WEST SUSSEX COUNTY COUNCIL CONSULTATION

TO:	Arun District Council FAO: Simon Davis
FROM:	WSCC - Highways Authority
DATE:	18 August 2021
LOCATION:	Land adjacent to Sefter School House Sefter Road Bognor Regis PO21 3EE
SUBJECT:	P/111/21/RES Approval of reserved matters following P/116/19/OUT for the erection of 2 No detached houses & 4 No semi detached dwellings. This site is in CIL Zone 5 and is CIL Liable as new dwellings.
DATE OF SITE VISIT:	n/a
RECOMMENDATION:	More Information
S106 CONTRIBUTION TOTAL:	n/a

Project
Land adjacent to Sefton School House
Sefton Road
Bignor Regis
PO21 3EE
Drawing Title
Block Plan as Proposed

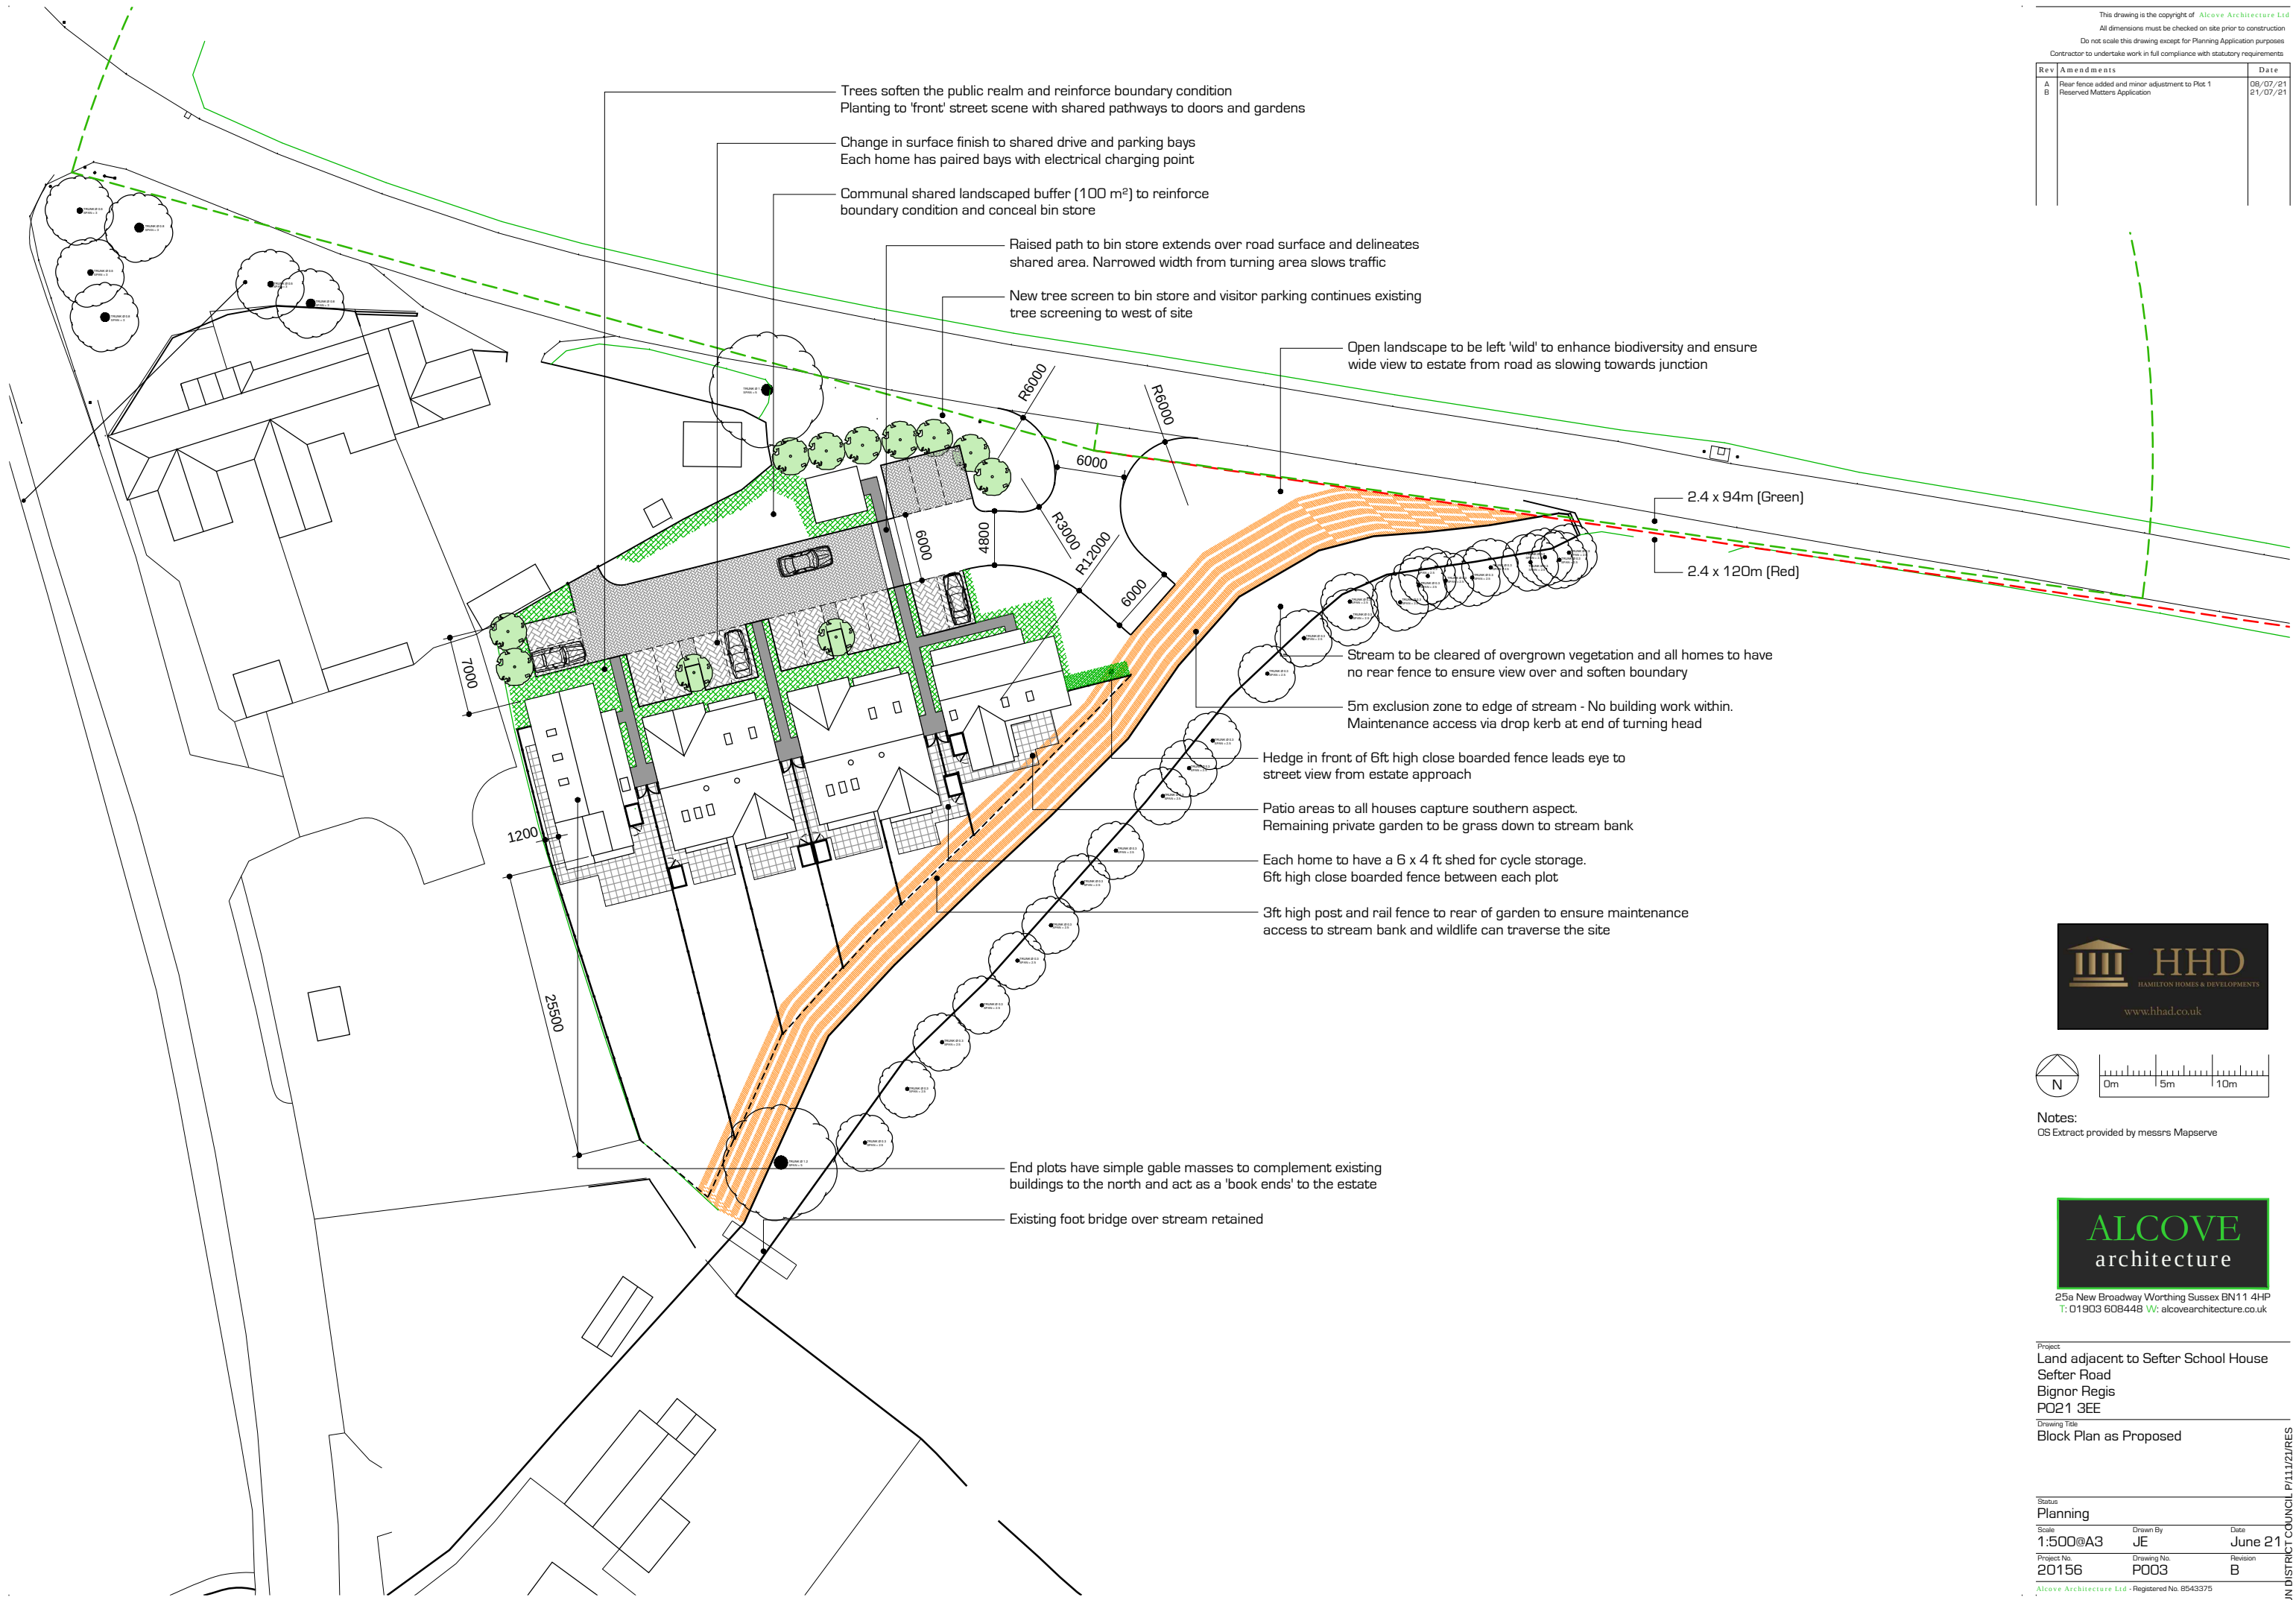
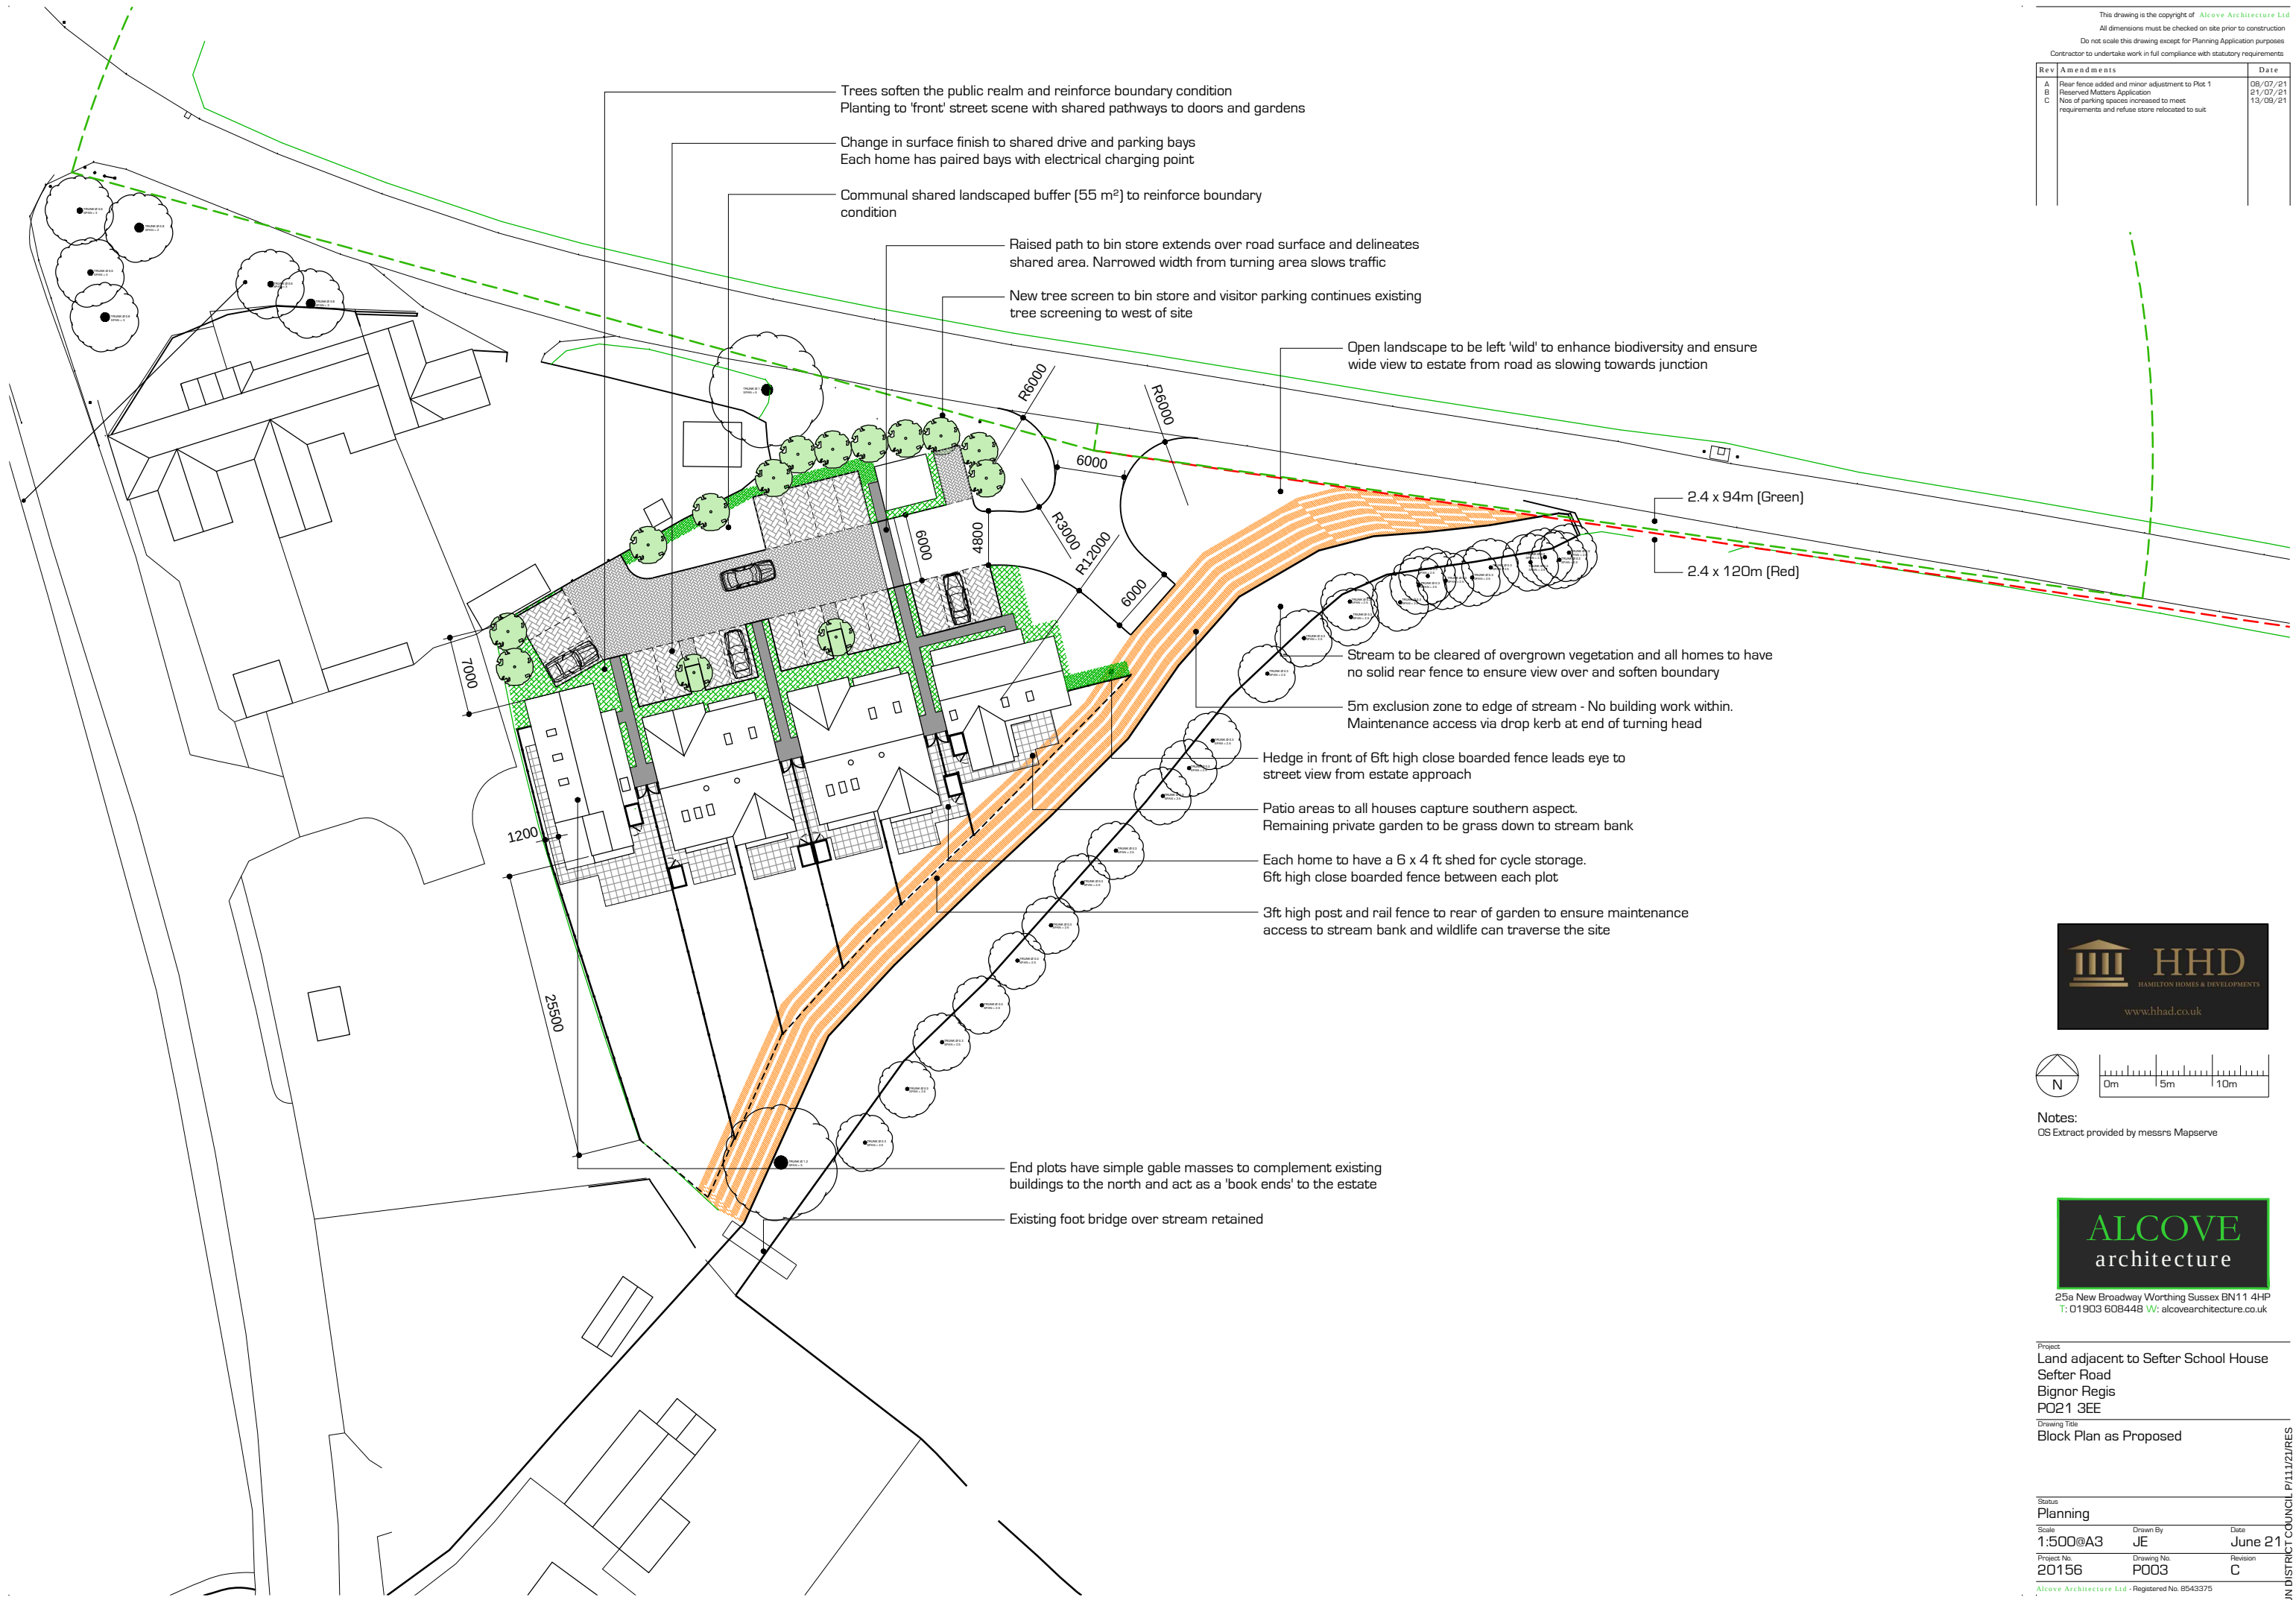
The above findings show that under WSCC and MfS Guidance the development will provide 12 allocated and 3 unallocated (visitor) parking spaces towards the provision of the site. This is 6 unallocated (visitor) spaces below the minimum recommendation made by the PDC.

The LHA requests the applicant seeks ways to implement these additional spaces within the site.

As per the WSCC Sustainability policy, the LHA wish to see cycle storage implemented in the form of lockable covered storage.

When reviewing the parking comments above, the LHA asks the applicant to consider the need for a turn on site.
